**MINOR MODIFICATION OF ORANGE WASTE PROJECT APPROVAL MP09\_0025 – FINAL  
RESPONSE TO PUBLIC SUBMISSIONS**

## Response to Second Round of Public Submissions – Orange Waste Project Minor Modification MP09\_0025

EUCHAREENA ROAD
SITE COMPARISON

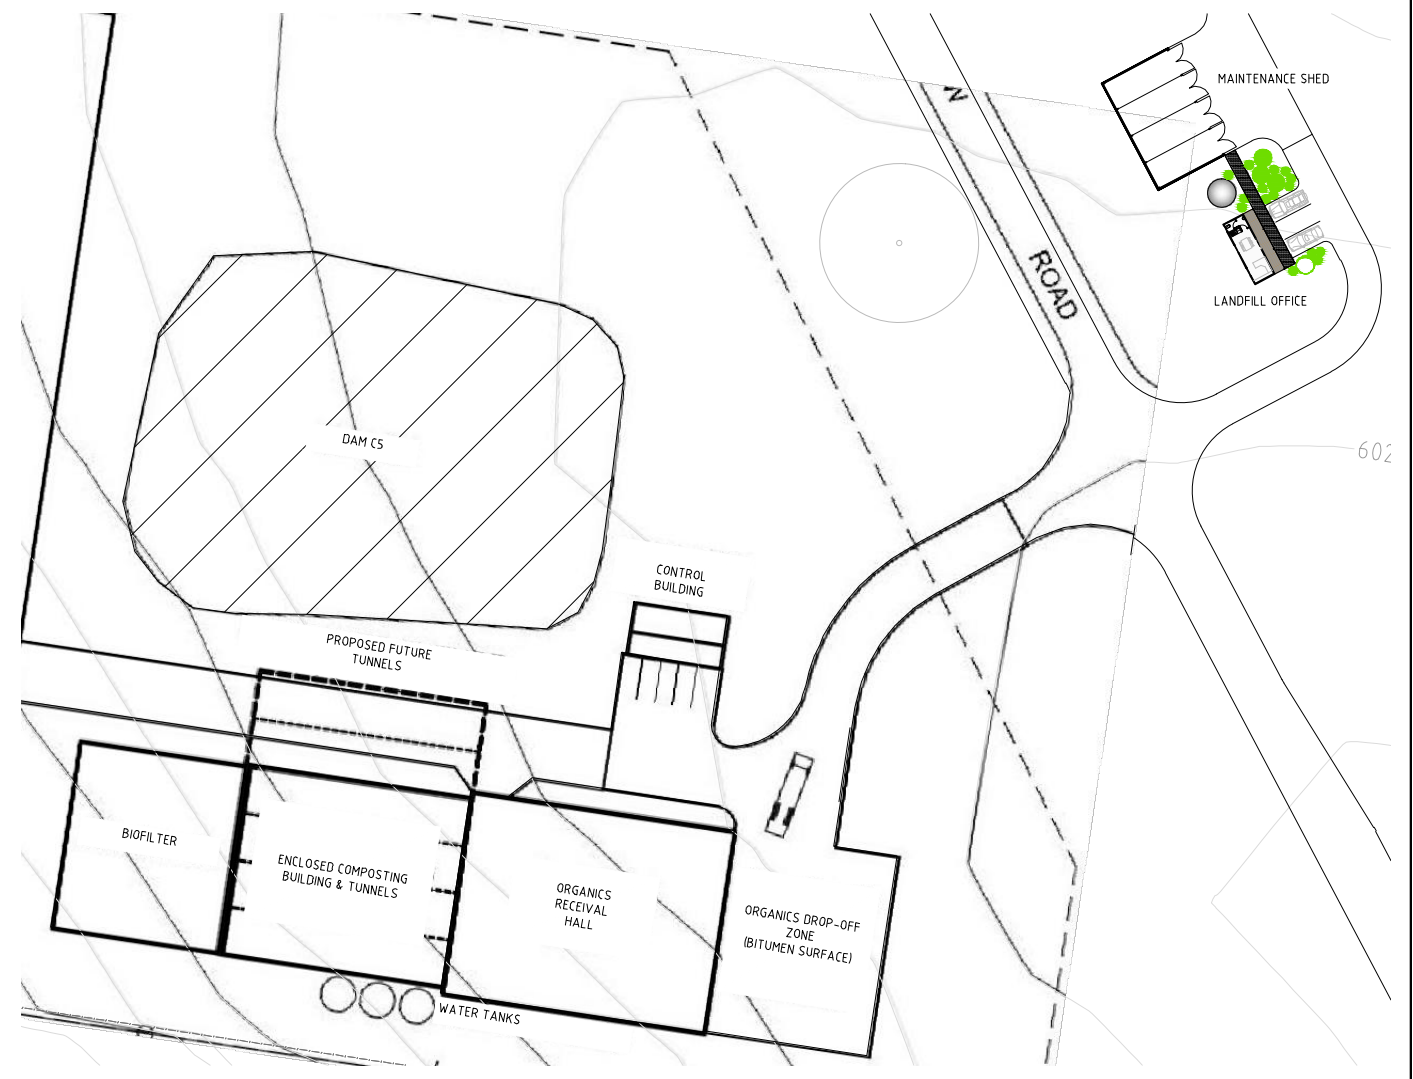
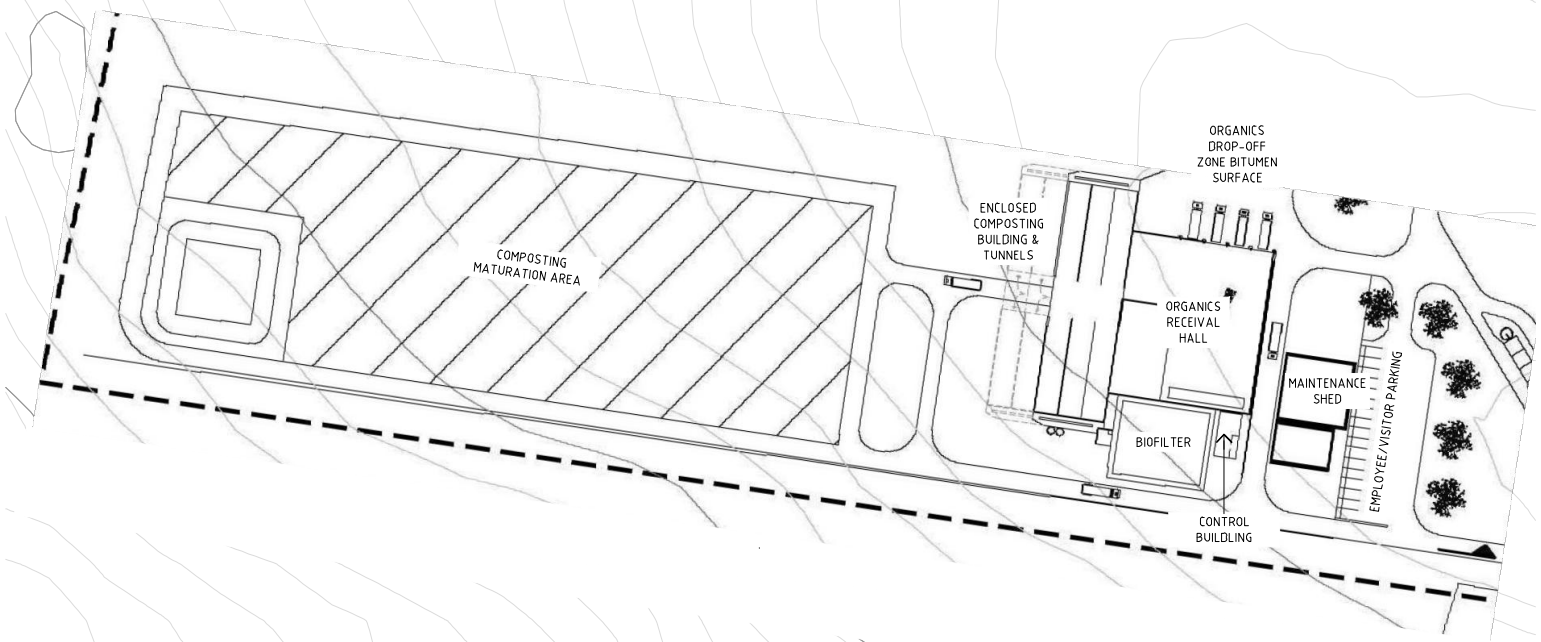
Issue No.	Comment	Response
2	Clarification sought as to the size of the increase in capacity of Dam C from 0.5ML to 10ML. Provide justification for this increase.	<p>It is confirmed that Dam C, with a capacity of 0.5ML, has been replaced with Dams C1 – C5, with a combined capacity of 10ML.</p> <p>The increase in dam capacity enables the facility to store sufficient water without any of the dams needing to be at 100% capacity. This increased capacity provides the reduction in the level of water in the individual dams during periods of high rainfall, thereby ensuring there is no uncontrolled release of liquid residue from the dams into the local water environment.</p> <p>Condition 22 of Schedule 5 of Project Approval MP09_0025 requires that a water balance be completed as a component of the yet to be completed soil and water management plan. A water balance analysis of the water needs of the site has determined that the site will require five megalitres of water for operational activities. The above capacity ensures that this requirement is met.</p>

Issue No.	Comment	Response
1	Insufficient details of the function of the additional 4 dams. Details of environmental mitigation measures and or lining required.	<p>The Evans and Peck Surface Water Assessment (Appendix J to the GHD EA) identify that the proposed function of Dam C (as originally designed) was to capture run-off from the composting maturation pad. Water would be extracted from this dam for maintenance of the moisture content required in the composting process. The report identifies that the composting maturation area will be isolated from the surrounding area by bunding to ensure that runoff from the area cannot drain to the surrounding land. The bunding would also ensure that runoff from the surrounding land cannot drain into the maturation area (page 24, Appendix J). This function has now been provided via Dams C3 and C4; see below.</p> <p>It was further clarified that stormwater drainage from the product maturation and product storage areas would be directed into a separate pond from which it would be recirculated into the compost (Page 28, Appendix J). The maturation pad would be sealed to prevent any leachate from the compost infiltrating into the surrounding soils. This function is now provided via Dams C1 and C2; see below.</p> <p>As per the above functions of Dams C1 – C4 remains the same as originally identified for Dam C, namely, that these dams will collect water from the compost maturation area and stormwater from the product storage areas. As the storage in these dams serves a pollution control function, it is exempt for consideration of the harvestable rights of the site (Page 35, Appendix J).</p> <p>Dam C5 will be used as a fire fighting resource. The dam serves no water harvesting role as water is to be pumped into this dam (referred to as a turkey nest dam). This dam is also therefore exempt from harvestable water rights.</p> <p>To clarify, the specific function of dams C1 – C5 is set out as follows:</p> <ul style="list-style-type: none"> <li>- C1: Capture and reuse of stormwater that has potentially been in contact with treated compost;</li> <li>- C2: Capture and reuse of stormwater that has potentially been in contact with treated compost;</li> <li>- C3: Captures residual runoff from composting process. Water in C3 will be used as top up water for the compost process and irrigation;</li> <li>- C4: Acts as a back up for C3 in times of high rainfall. When water levels in C3 reduce, water from C4 will be pumped back to C3. C4 will normally be less than 20% full; and</li> <li>- C5: To be used as a fire fighting resource. Serves no water harvesting role as water is to be pumped into this dam (a turkey nest dam).</li> </ul> <p>The design of these dams represents best management practise for water storage in respect of pollution control as identified by the NSW Office of Water.</p>

Issue No.	Comment	Response
1	Additional dams: Seeks clarification on whether impact of additional dams has been assessed and clarification on whether this remains a minor modification.	<p>As previously stated above, the function of Dams C1 – C4 remains unchanged from that proposed for former Dam C. These dams are to be used for pollution control purposes only and represent a best management practise approach.</p> <p>Dam C5 is a turkey nest dam to be used for fire fighting purposes.</p> <p>Response below to point 7 of the comments of D &amp; A Trowbridge addresses the matter of whether the changes to the dams represent a minor modification.</p>
2	Additional dams: seeks clarity on the source, quality and end use of water within these dams.	Addressed above.
3	Additional dams: inherent attractor for bees and biosecurity risk	<p>The Apiculture Risk Management Plan notes at page 18, that: <i>Liquid residue collected from green waste may be accessible to bees. However; it is assumed that any insecticide which migrated into this liquid residue would be subjected to significant dilution, effectively removing any risk to apiculture.</i></p> <p>Additionally, Orange City Council has sought the comments of Assure Quality on this matter. They advise that they believe there would be no significant change in the risk to apiculture from this modification.</p> <p>It was agreed that there may be an increase in attractiveness associated with an increase in available water on site but it was also suggested that a significant increase in dilution potential would further reduce the risk associated with water in the dams.</p> <p>Additionally, as bees are more attracted to more odoriferous water sources, there is a possibility that more dilution would cause a reduction in the attractiveness of the water.</p> <p>On the above basis, it is considered that the additional dams will not result in any greater impact to the apiary industry than that which was approved via the project approval.</p>

4	Additional dams: will they be lined?	Dams C1 – C5 will be constructed in the same manner as was proposed for original Dam C. No change is proposed. It is noted in the Groundwater Assessment, prepared by Aquaterra Consulting Pty Ltd (GHD EA, Appendix K), that Dam C was to be clay lined with a minimum of 900mm of material (Page 38, Appendix K). No change is proposed to this construction method.
5	Additional dams: proposed storage capacity exceeds harvestable rights.	<p>As previously stated, the function of dams C1 – C4 remains unchanged as the proposed function of Dam C, ie, for pollution control. As such these dams are exempt from harvestable rights calculations.</p> <p>Dam C5 is a turkey nest dam and forms no harvesting function, it is also therefore exempt from harvestable rights.</p>

2 PROPOSED SOUTHERN ELEVATION

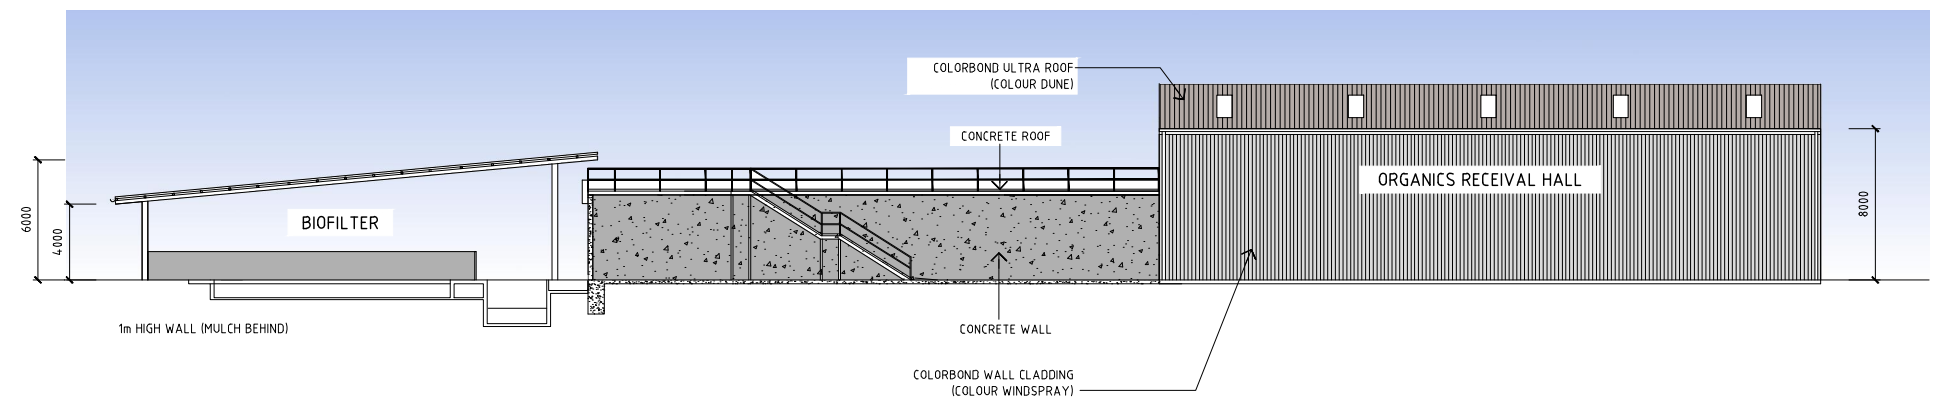
Issue No.	Comment	Response
2	<p>Implications of the receival hall having an open end in terms of visual amenity, noise and air issues. The realignment of the building may have an adverse impact on the amenity upon the nearby resident.</p>	<p><b>Noise:</b> The Noise Assessment completed by Heggies Pty Ltd (Appendix Q, GHD EA) confirms that the composting tunnels will be sealed hermetically by a tunnel door to contain odour and leachate (Page 10, Appendix Q). The modification does not seek to make any change to this arrangement. The composting tunnels remain enclosed and sealed as per the original project approval and noise assessment.</p> <p>The Noise Assessment confirms that operations within the composting tunnels would occur 24 hours a day/7 days a week (Page 16, Appendix Q). No change is proposed to this arrangement. As above, these tunnels will be hermetically sealed. There is no reference to activities within the receival hall occurring on this same frequency. It is specifically noted in the Air Quality Assessment, also prepared by Heggies Pty Ltd, that 'some components of the compost plant would operate on a 24 hour a day basis albeit with negligible noise generated' (Page 9, Appendix O).</p> <p>The Noise Modelling that was undertaken by Heggies took into account source sound level emissions and locations, screening effects, receiver locations, meteorological effects, ground topography and noise attenuation due to spherical spreading and atmospheric absorption. The noise modelling did not specifically address the effects of the undertaking of operations within either a completely or partially enclosed building. The modelling did consider composting in the two operation scenarios (Page 18, Appendix Q).</p> <p>In addition to the above it is noted that Appendix D of the Heggies Noise Assessment report contains a table showing the modelled noise of specific machinery types. The table implies that no building has been allowed for in the modelling - in other words, the individual noise sources within the building have been modelled directly, without reducing their noise levels due to the presence of a building.</p> <p>Therefore, whether there are roller doors or not in practice, the actual noise levels should be lower than those modelled in the noise assessment.</p> <p><b>Air/Odour:</b> The scope of the air quality assessment, prepared by Heggies Pty Ltd (Appendix O, GHD EA), was to identify existing air quality characteristics, identify suitable air quality management controls and determine the likely impact of the Euchareena Road RRC on local air quality, including both particulate matter and odour (Page 7, Appendix O).</p> <p>The Air Quality Assessment confirms that the composting tunnels would be hermetically sealed to contain odour and leachate (Page 12, Appendix O). It is confirmed that this approach remains unchanged by virtue of the minor modification application.</p> <p>The Air Quality Assessment set out initial assumptions that were made in deriving the emission inventory model. It was noted:</p> <p style="padding-left: 40px;">It has been assumed that as the front-end loader operation, waste unloading and shredding is carried out within the composting plant, a 30% particulate reduction factor has been applied, relating to partial enclosure (Page 31, Appendix O).</p>

Issue No.	Comment	Response
1	Inadequacy of drawings: drawings do not show the detail of the building including which side is open.	<p>Detailed design has been undertaken since project approval was granted which has, as might be anticipated, resulted in the preparation of detailed plans of the development.</p> <p>In respect of the modification application the proponent has sought to remain consistent with the level of information provided in the project approval. It is acknowledged that this has resulted in a perceived lack of information.</p> <p>Attached to this response are detailed plans of the composting facility. These plans are consistent with the written descriptions provided in the previous documentation relating to the minor modification application.</p>
2	Inadequacy of drawings: no detail has been provided on design of composting tunnels.	See above.
3	Noise and Odour: Realignment of the receival building and the prevailing direction of winds has ramifications for the nearest receptor, 'The Shades'. The noise and odour assessment are affected by the change to the alignment of the building	<p>As previously stated, the air quality assessment was undertaken on the basis that the composting facility was partially enclosed. Therefore the proposed modification to have this building open on the eastern end does not affect the conclusions of this report. No change is proposed to the management of the air within the tunnels, and the shredding facility which would have received original food and garden waste unsorted and un-shredded has been located at Ophir Rd. Fresh or recycled air would be blown into each tunnel by fan, with surplus exhaust air being discharged to a biofilter (Page 10, Appendix Q).</p> <p>As stated above in the response to comments received from the HUB Action Group, it is noted on page 33 of Appendix O of the GHD Environmental Assessment, prepared by Heggies Pty Ltd and submitted in support of the original application, that the receival hall at Euchareena Road would not be fully enclosed. It follows that this assumption forms the basis of the reports prepared by Heggies Pty Ltd, including the Noise Assessment.</p> <p>Subject to the above, and in consideration of Condition 26 of Schedule 5 of the Project Approval, it is not anticipated that noise transfer to nearby residential receivers would be increased via this modification application.</p>
